WILKINS ENGINEERING, P.C.

May 24, 2023

REFERENCE: Deck Framing Changes
310 Wyndham Place Drive, Fuquay Varina, N.C.
Harnett County Permit BRES2212-0014

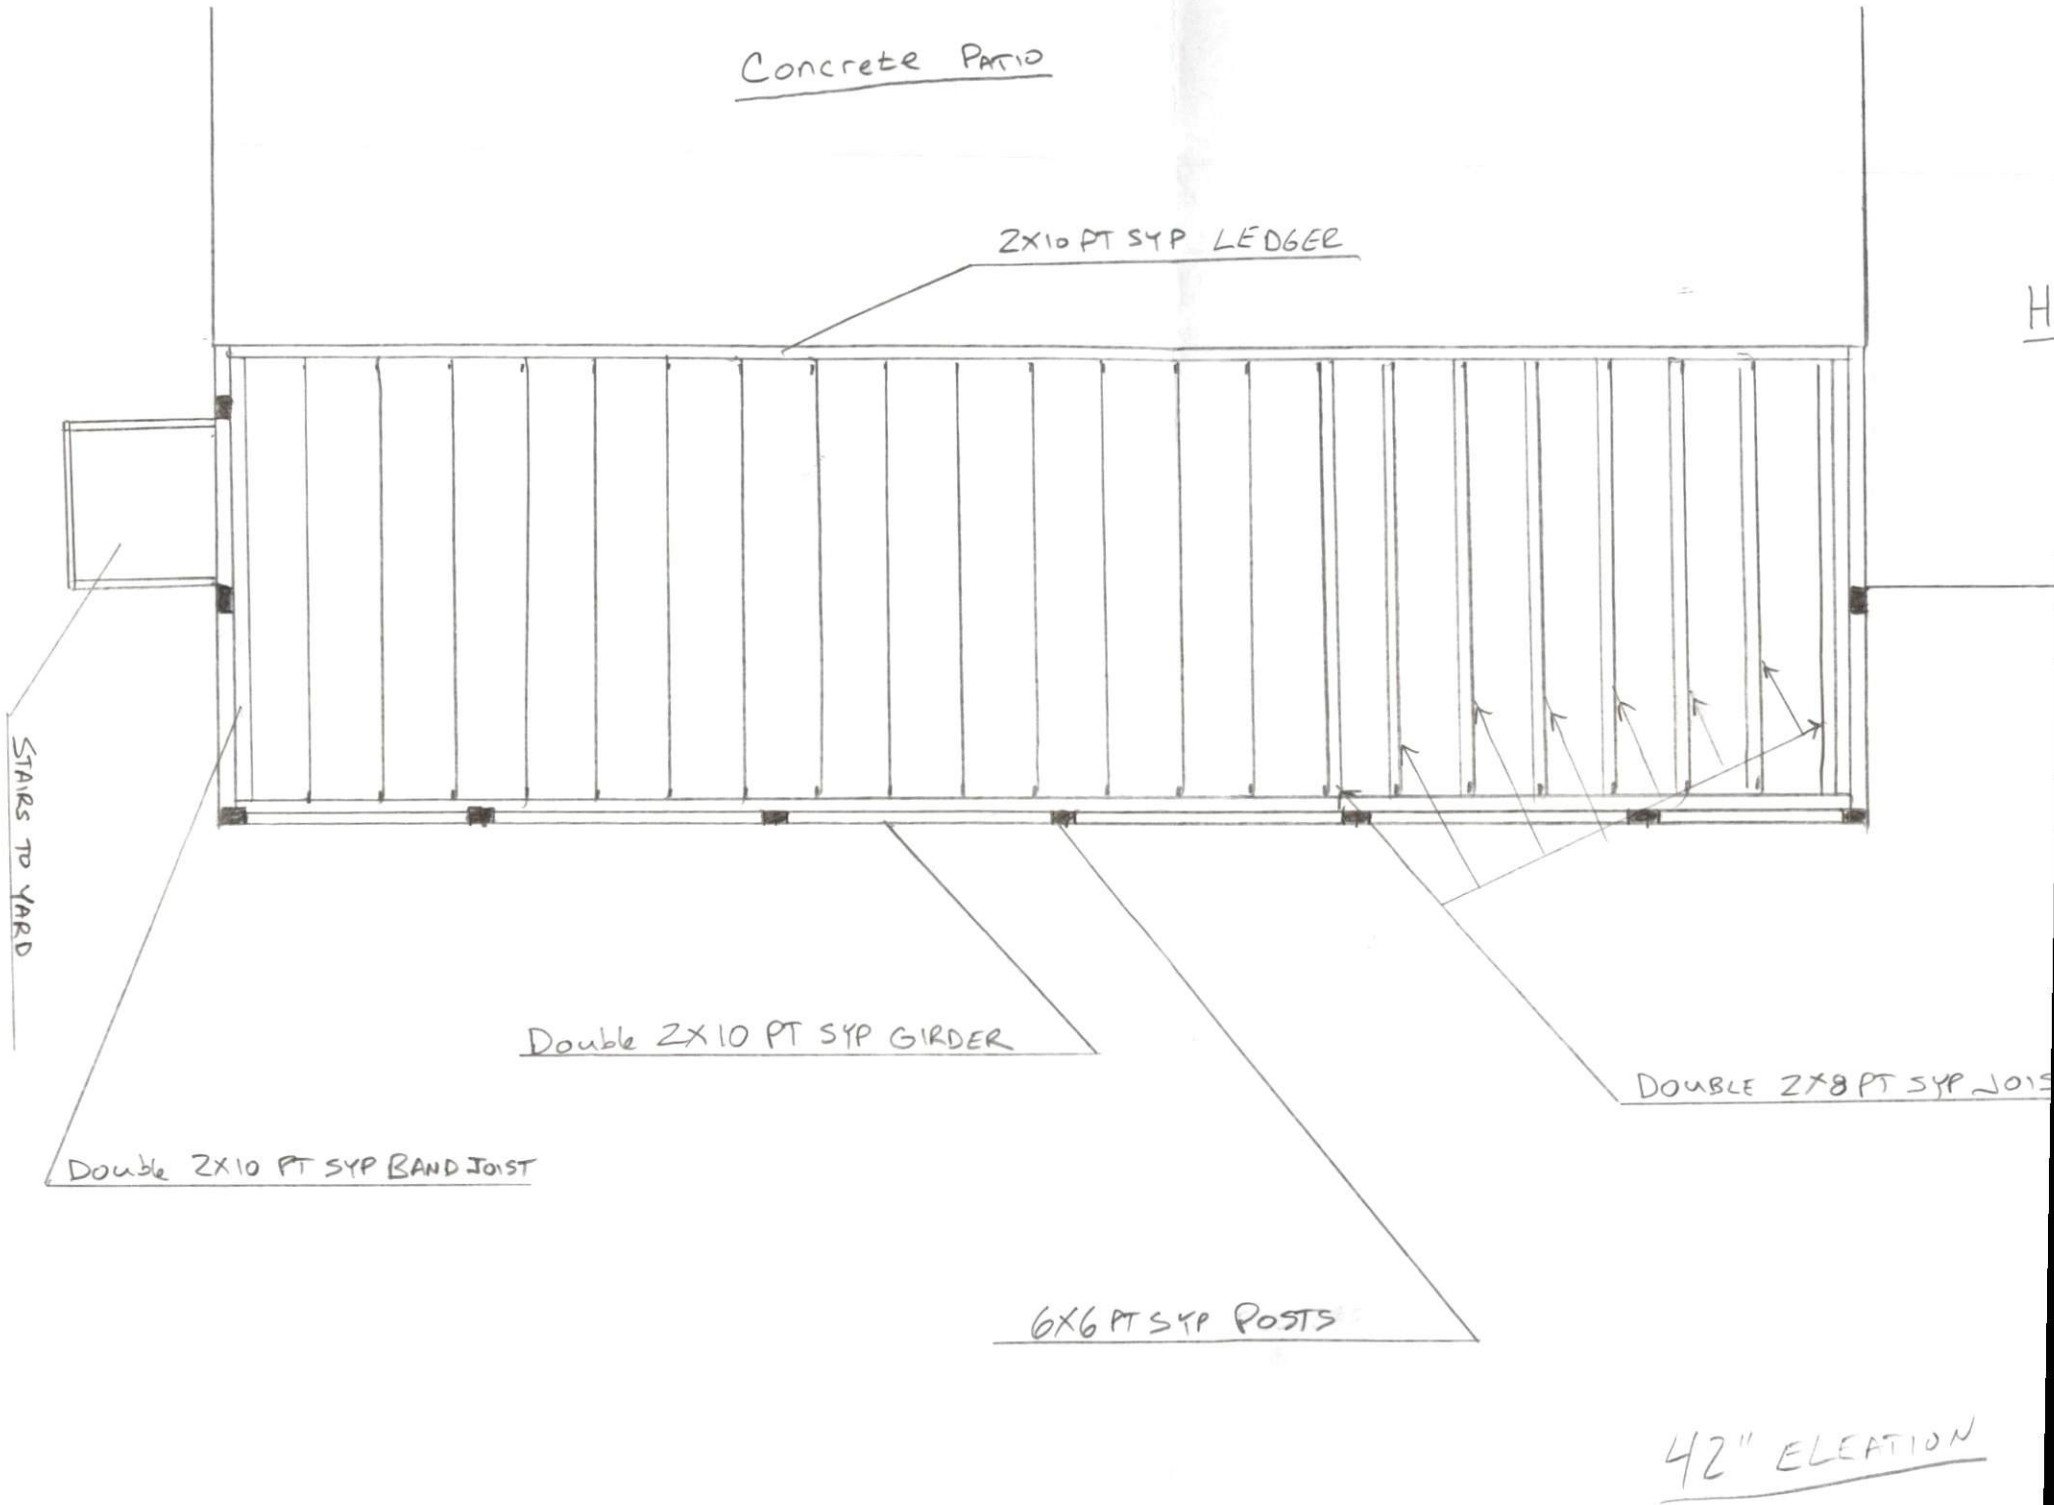
The original design drawing for the proposed 34'-0" x 7'-0" rear deck called for 2" x 10" floor joists installed at sixteen inches on center. I have evaluated a design change to allow 2" x 8" floor joists at sixteen inches and found that material substitution to be structurally acceptable. All other framing should be installed as shown on the original design drawing. Accordingly, the floor joist substitution as noted above meets the requirements of the 2018 NC Residential Building Code.
